**KIRKLEES METROPOLITAN COUNCIL
INVESTMENT & REGENERATION SERVICE**

DELEGATED DECISION TO DETERMINE PLANNING APPLICATIONS

Reference No:	2023/62/93406/W
Site Address:	3, Lightridge Close, Fixby, Huddersfield, HD2 2HW
Description:	Raising of ridge height of existing roof, erection of two first floor and single storey extensions and formation of first floor terrace to south elevation, erection of extension to north elevation including infilling of existing open sided porch and erection of canopy across the north elevation, insertion of roof lights and associated alterations
Recommending Officer:	Lucy Taylor

Officer Report.

STATUS PLANNING DRAWING		PROJECT TITLE LIGHTRIDGE CLOSE	
DRAWING TITLE PROPOSED GA		DRAWING TITLE PROPOSED GA	
SCALE 1:50	DRAWN EG	CHECKED JH	PROJECT REFERENCE ODS 23/701
PAPER SIZE A1	DWG NUMBER (20)001	DATE 13/11/23	REVISION /
CLIENT MR & MRS TAYLOR		CLIENT MR & MRS TAYLOR

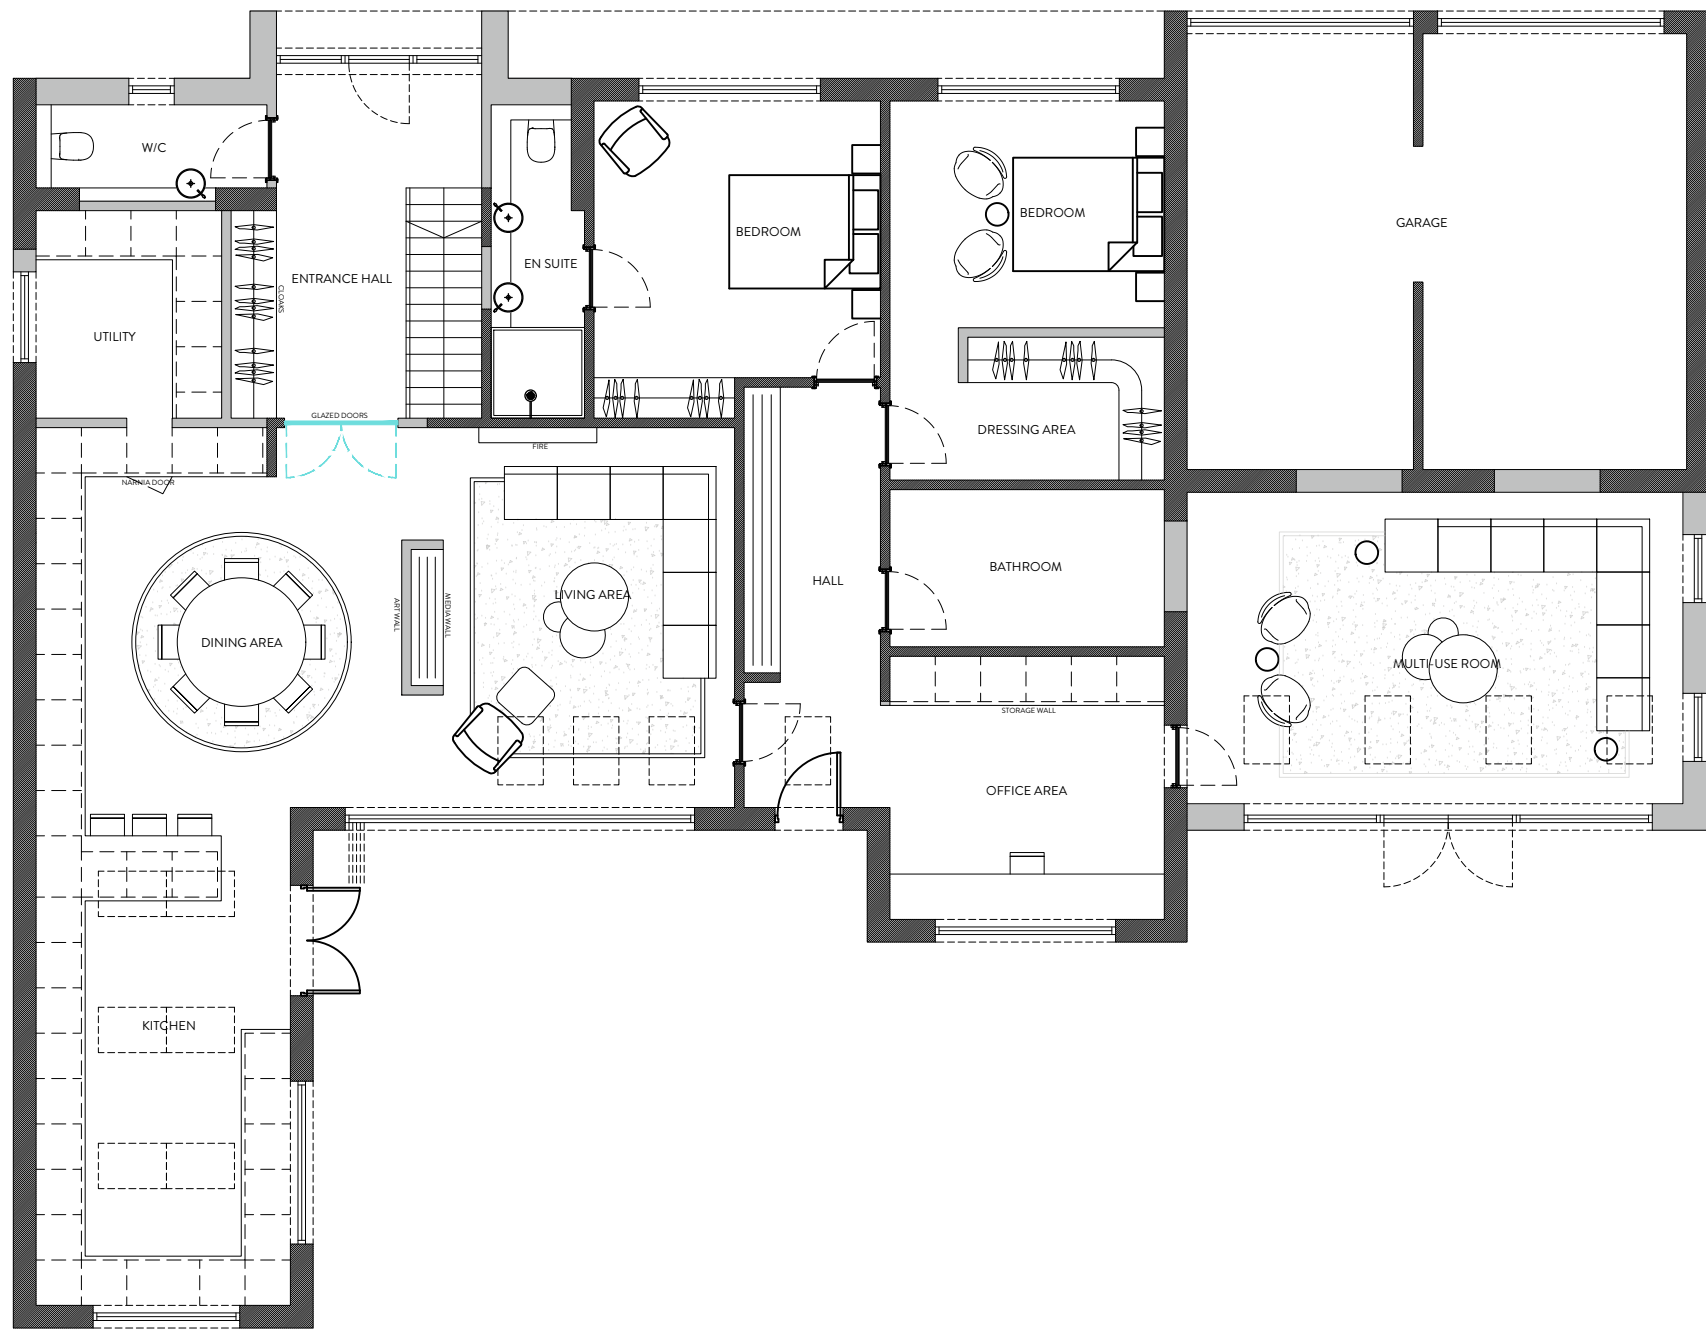
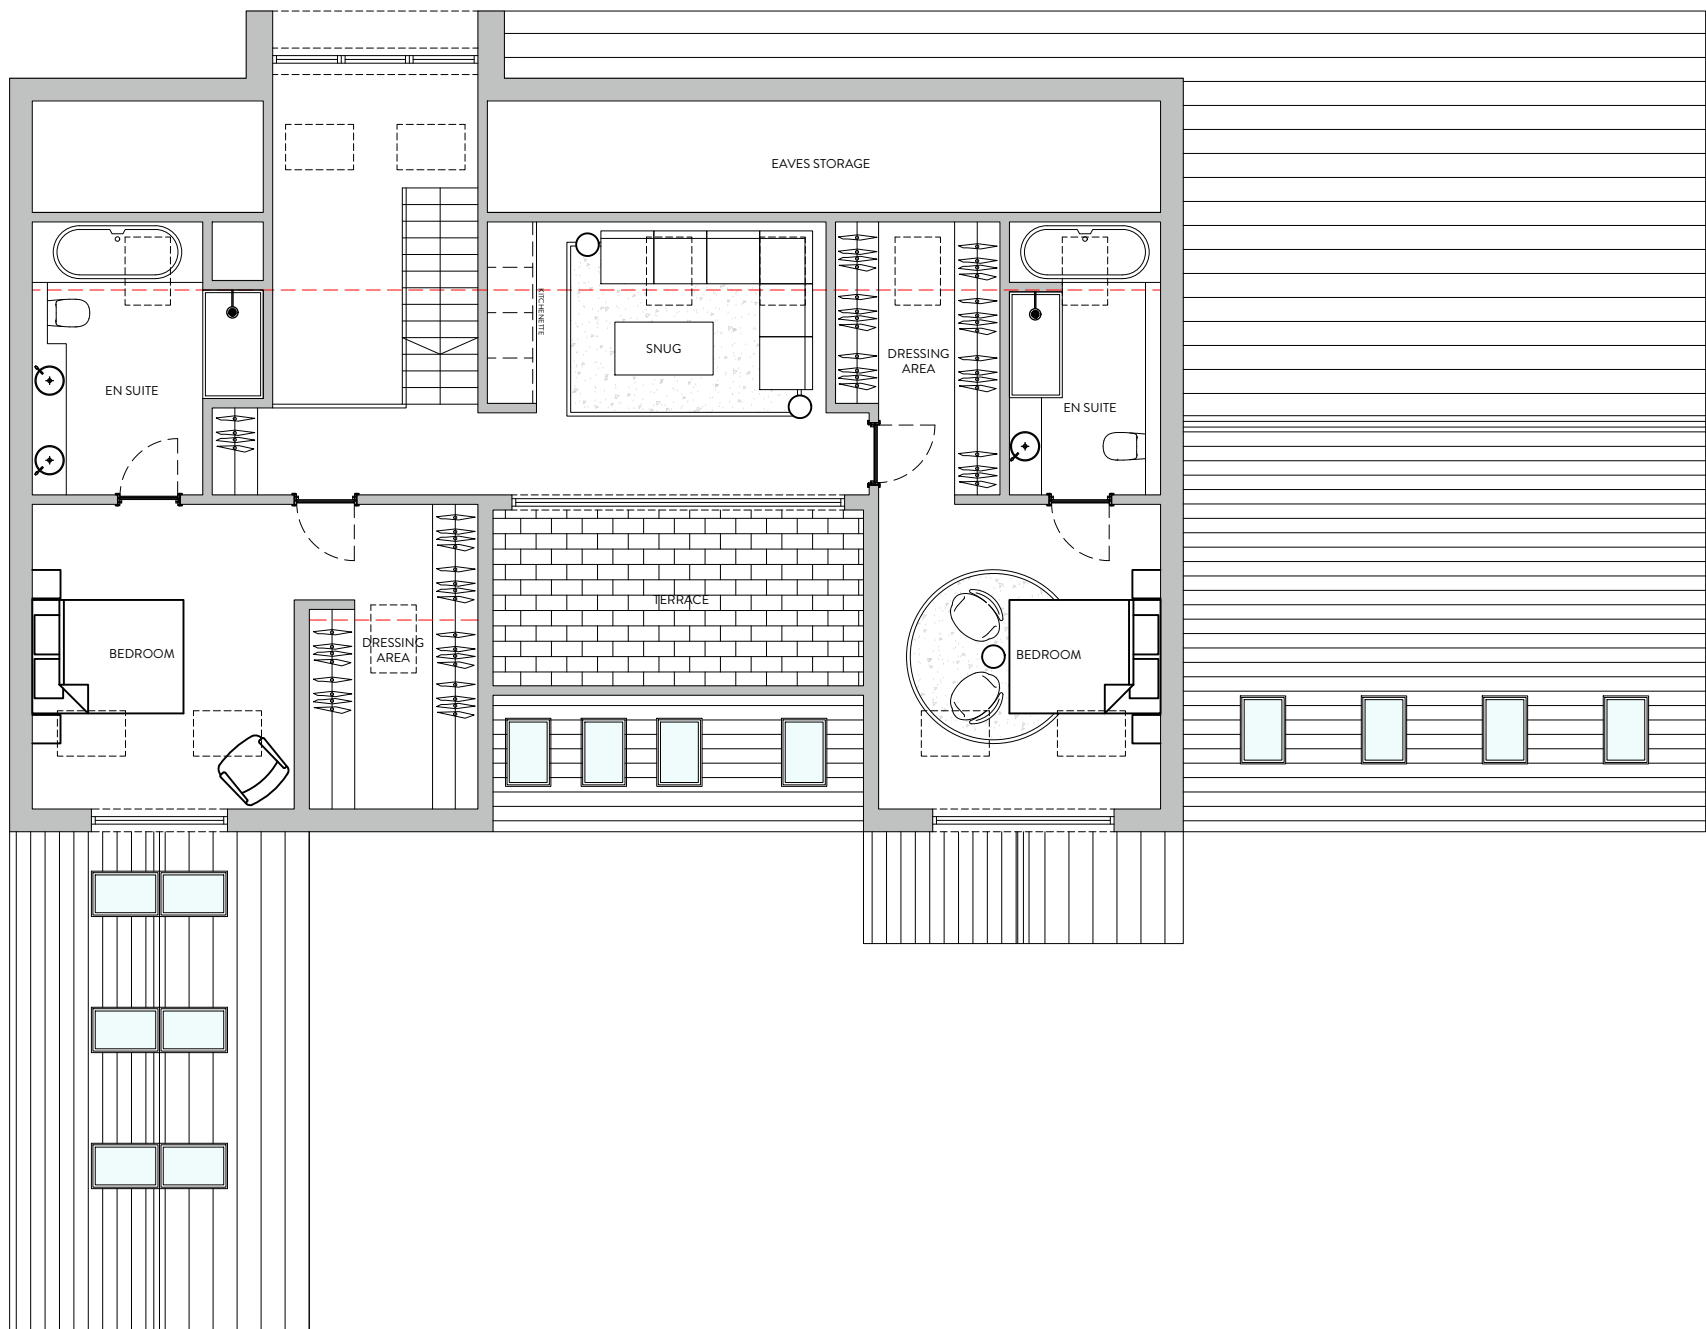
The case officer entered into negotiation with the planning agent / applicant and as a result, the following amendments were made to the scheme:

- Reduced rear gables below the ridge level.
- Reduced single storey entrance porch.

These amendments are shown on the latest plan submitted (Dwg No. (20)001 Rev B), which has been used to determine this application.

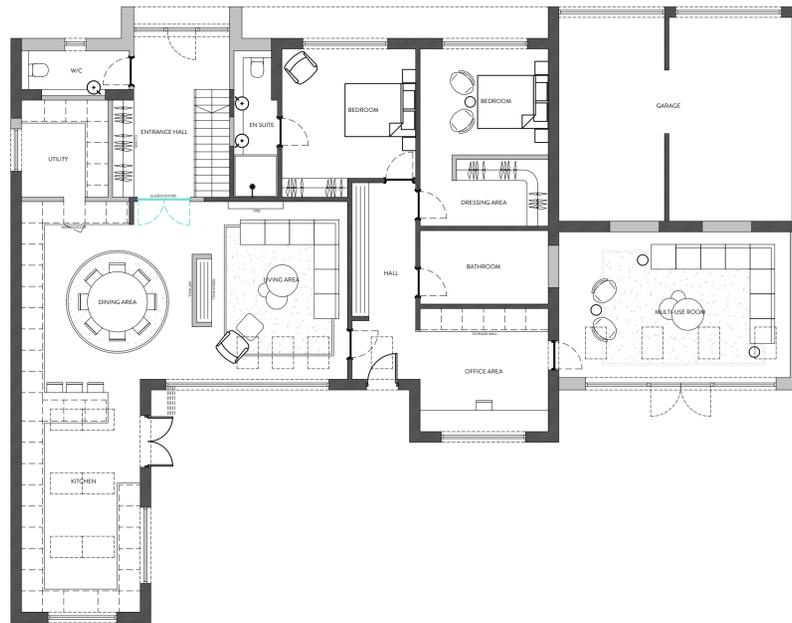
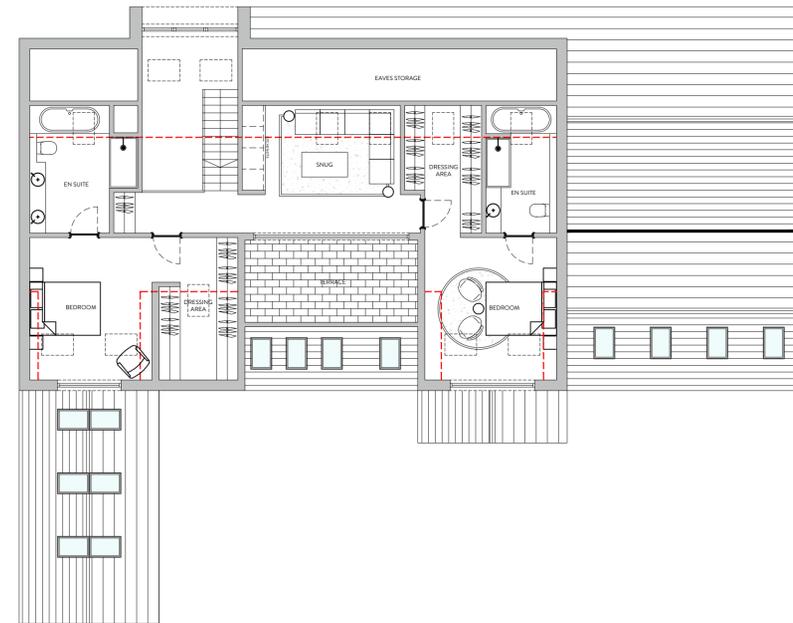
- Reduced single storey entrance porch with glazed infill set back creating a covered porch area. We believe the glazed gable at single storey is appropriate considering the full height glazing on the ground floor front elevations of other properties on Lightridge Close, along with the fact that the single storey projection is set back from the road and screened with planting.
